Our Ref: LU/248/19/DOC

Approval of details reserved by condition imposed under ref APP/C3810/W/18/3197149 (LU/162/17/PL relating to Condition Nos 8 - materials & finishes, 9 - landscaping scheme, 10 - Construction Management Plan, 13 - visibility splays, 14 - pedestrian visibility plays, 16 - cycle parking and 18 - street lighting.

Land At Toddington Farm North And West Of 1 To 3 Toddington Toddington Lane Littlehampton BN17 7PN

Condition Number 16

Proposed Garden Shed - 1:50 @ A1
(secure cycle storage)

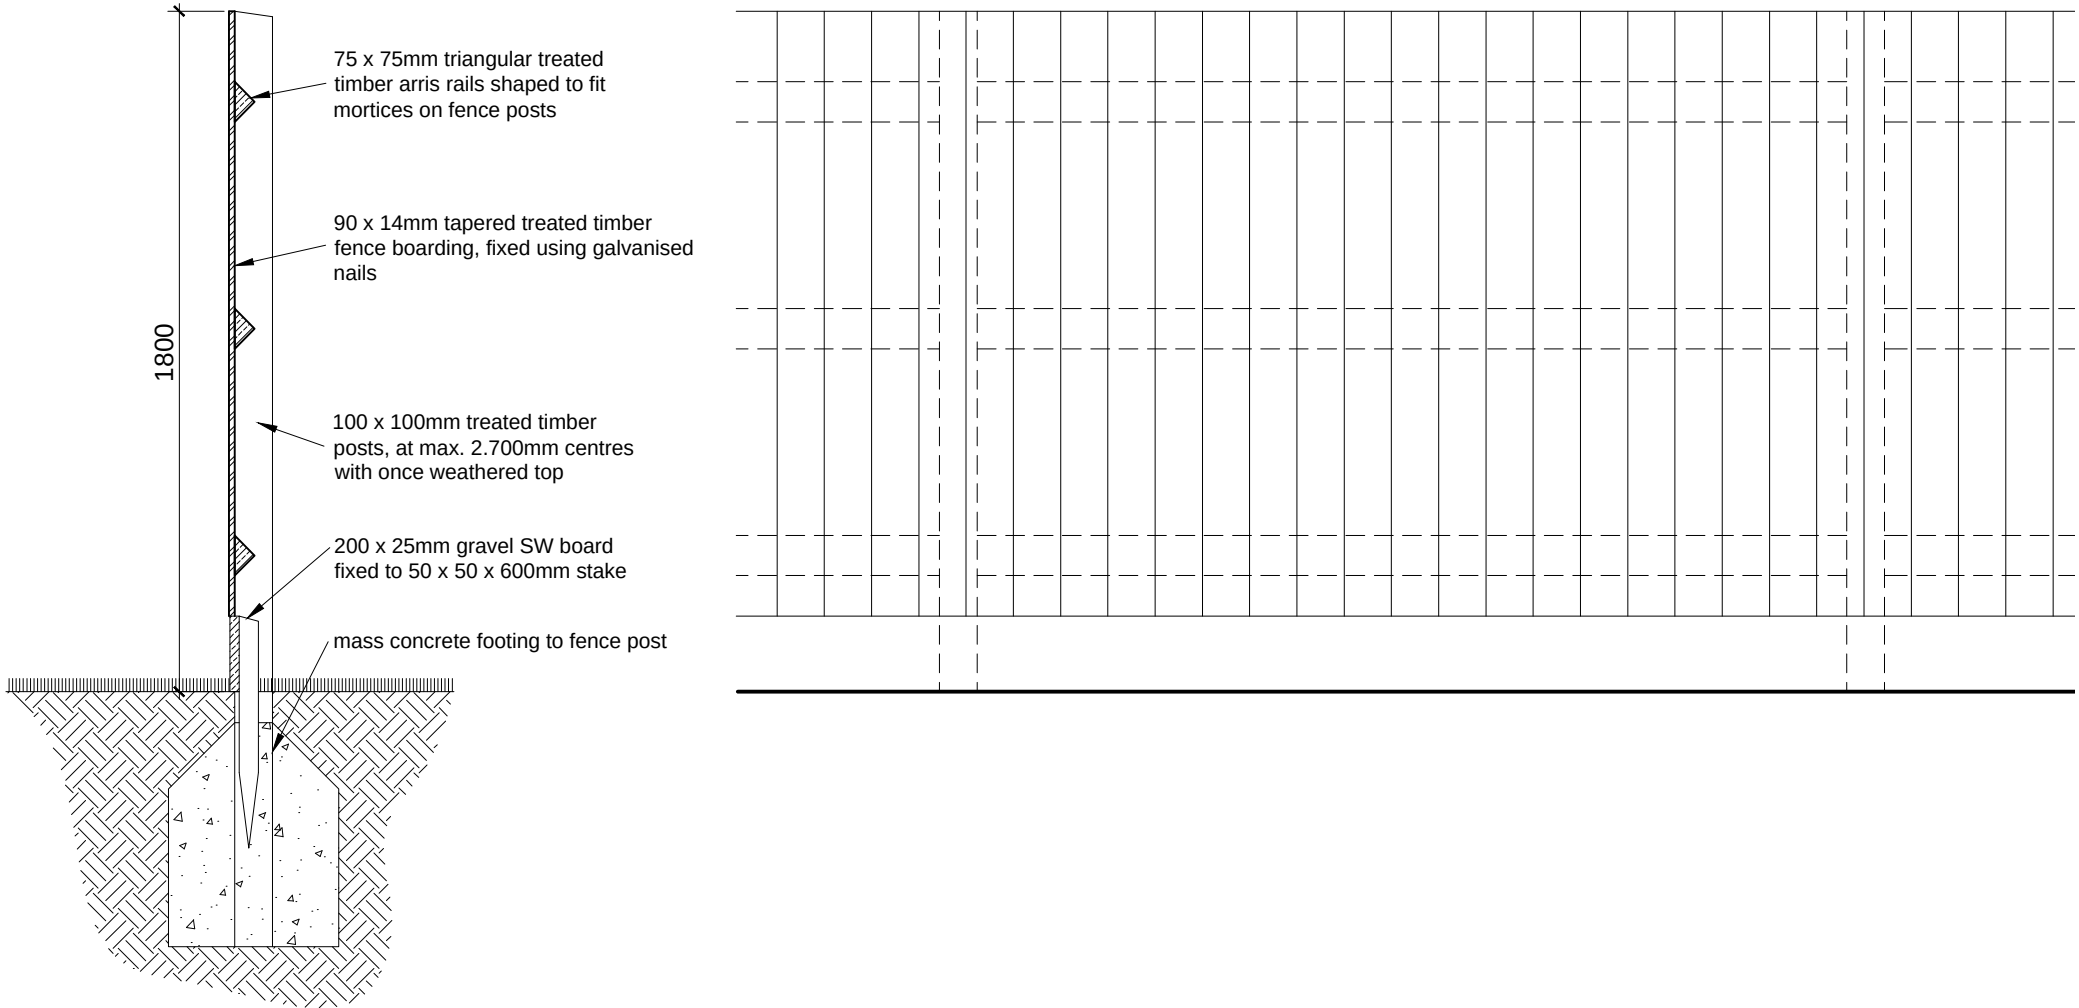
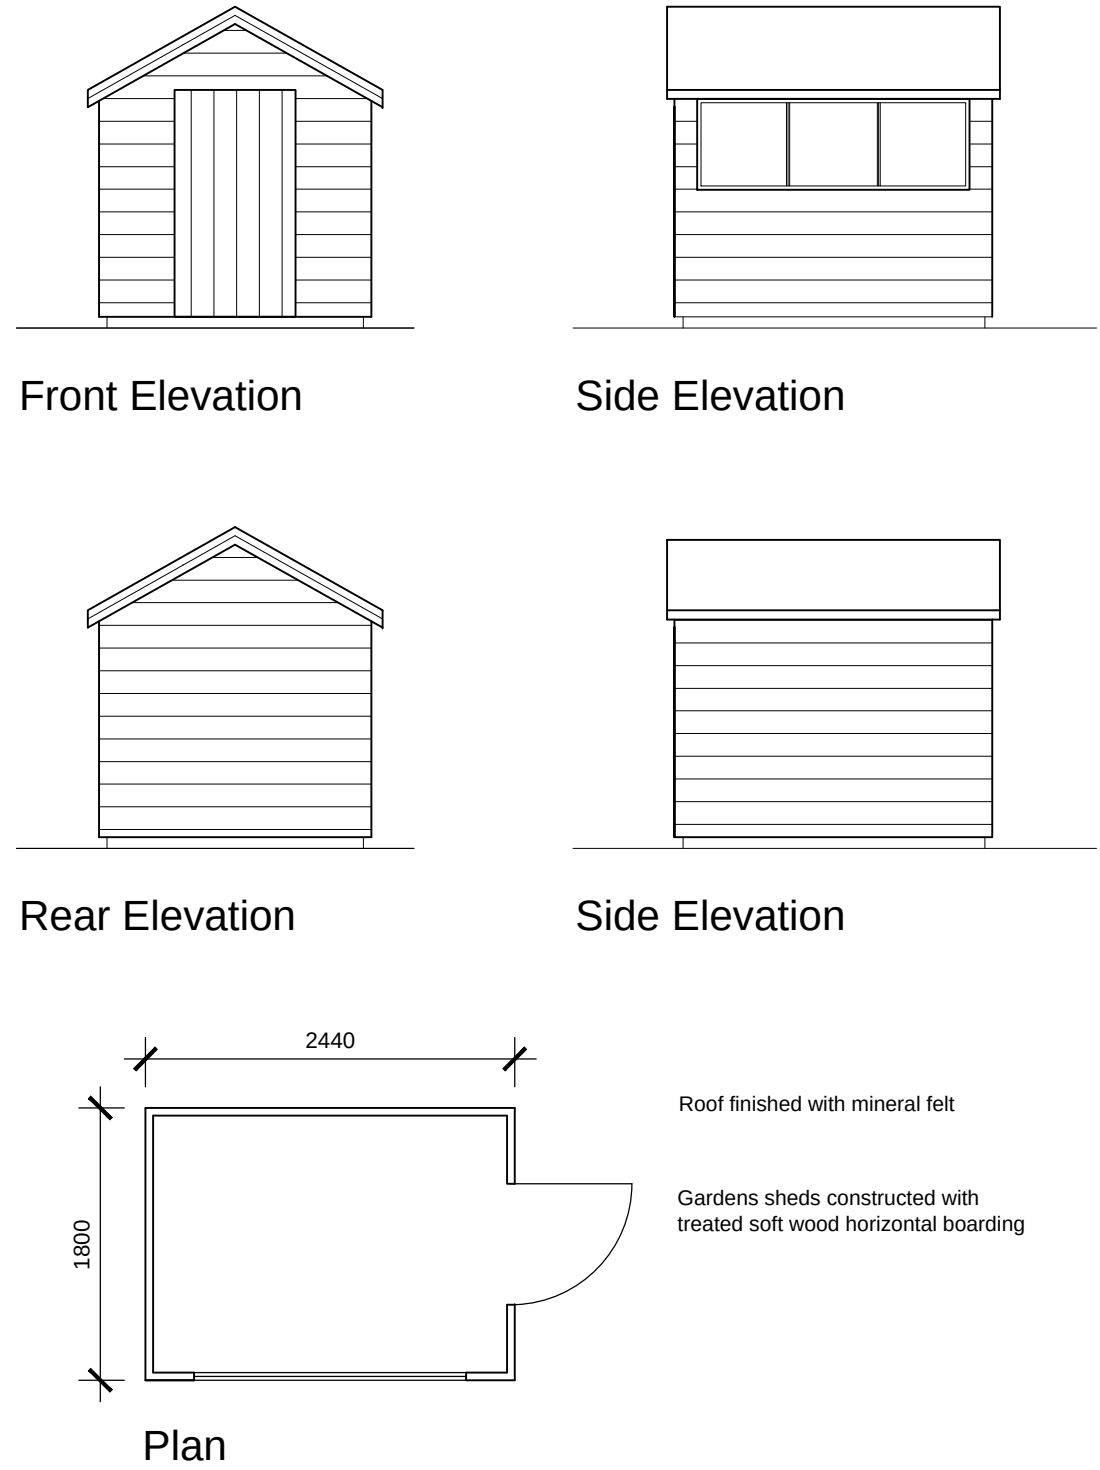
The submitted details are not acceptable in that access for plot 6 is not shown and access to shed to rear of plots 4/5 appears somewhat restricted. Shed would benefit from being moved slightly further westwards away from the access gate.
